CITY OF PORTLAND, MAINE

November 29, 2018

| Project Name: | Building and Parking Lot Expansion | Project ID: | PL-000232-2018 |
| Address: | 90 Johnson Road | CBL: | 214A A001 001 |

Drawing file: Drawings / c-3.0_site_layout_and_utility_plan.pdf

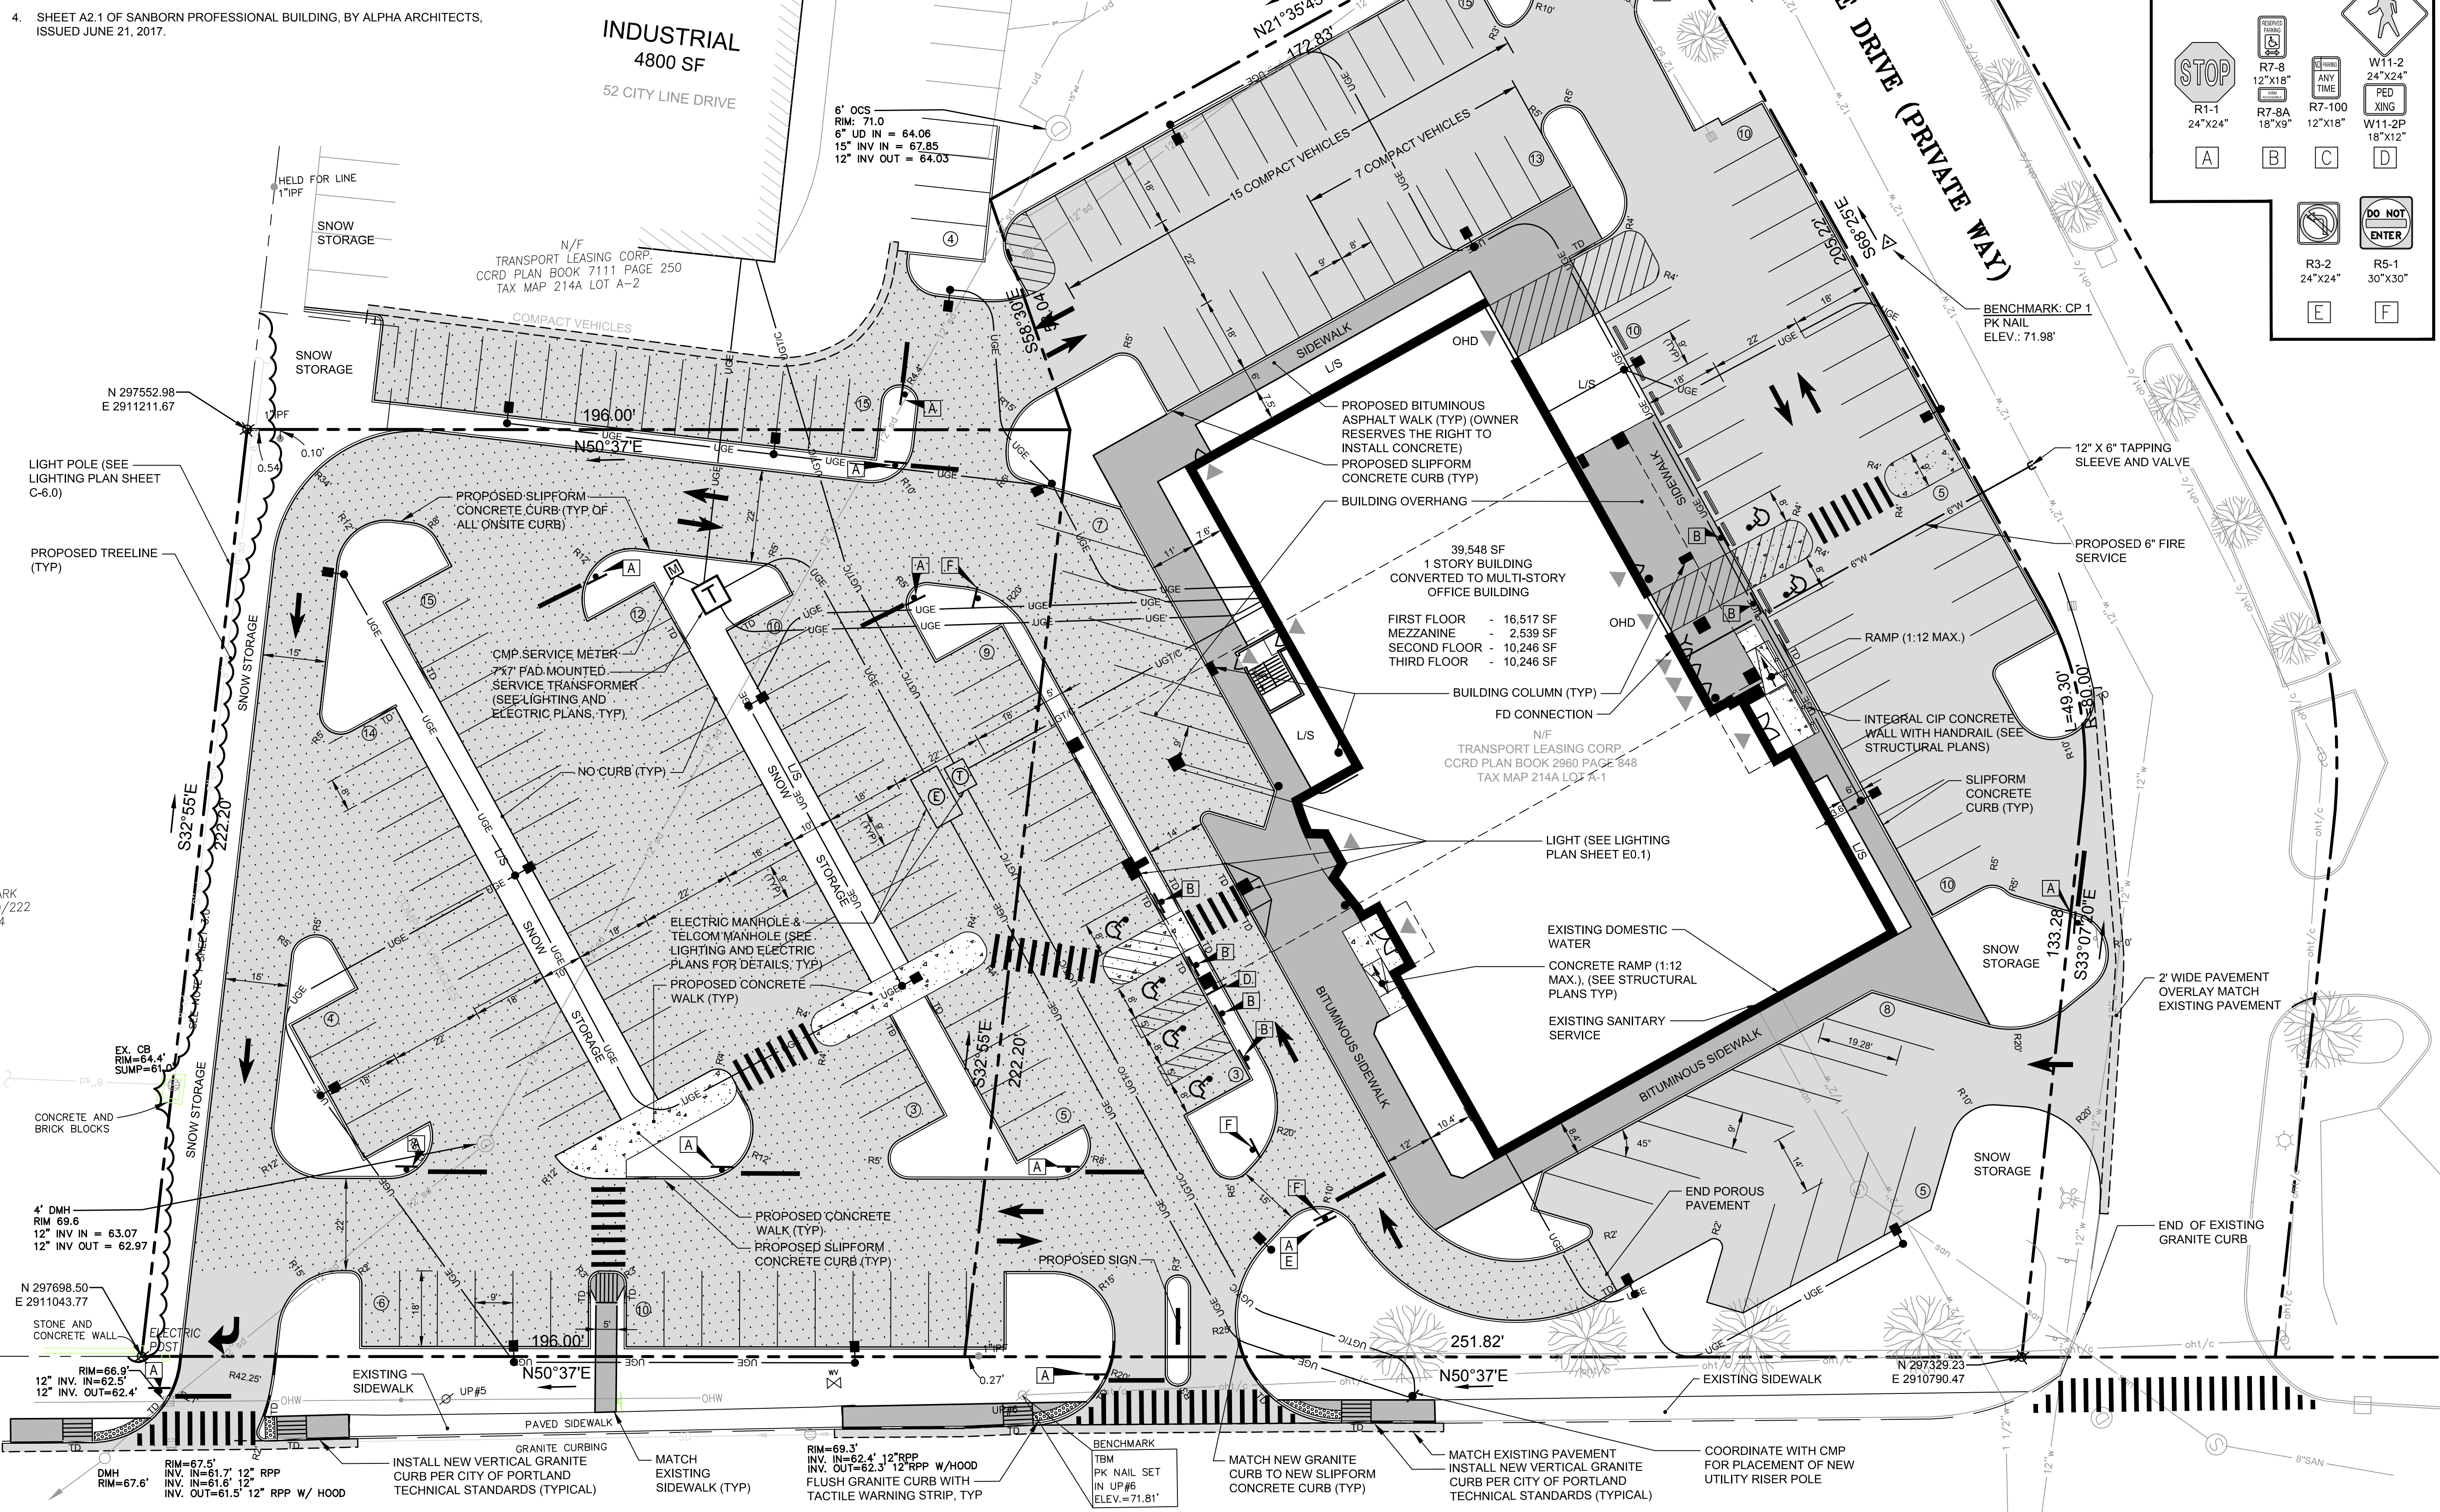
1. That the applicant shall post a Performance Guarantee to cover the costs of the entire development improvements; and
2. Detectable Warning Panels on the exit only driveway on Johnson Road are not required by either by City standard or American with Disability Act (ADA) and shall be removed.

5. That the inbound bus stop shall be fully compliant with American with Disability Act (ADA) by ensuring a full 5' x 8' bus stop landing area at this location. The outbound bus stop on Johnson Road improvement shall be based on the conclusion of the Traffic Study and/or Traffic Movement Permit; and

6. That the applicant shall revise the final plans to provide a direct, bi-directional sidewalk connection to the development to be reviewed and approved by the Planning Authority; and

7. That the applicant shall formally close the driveway apron by the addition of curbing and loam/seeding the effect area as shown on the site plan. Any amendments to the driveway and access points are subject to review and approval as part of the traffic study; and

For the final condition once the office building expansion takes place, a more direct, bi-directional sidewalk connection is to be designed.

Detectable Warning Panels on the exit only driveway on Johnson Road are not required by ADA. If they are installed by the applicant, they are to meet the city's current standard of Cast Iron with a 4" concrete border. If not, the plans are to be revised; if they are used; a note or detail indicating the use of cast iron is to be provided.

Due to the site plan not extending to show the vicinity of the existing bus stop on City Line Drive and Jetport Blvd, I would like an explicit Condition of Approval to be that the applicant will make the inbound bus stop fully ADA-compliant by ensuring a full 5' x 8' bus stop landing

area is provided at this location. This was a previous comment. Improvements to the outbound bus stop on Johnson Road are to be pending the outcome of the Traffic Study and/o Traffic Movement Permit.
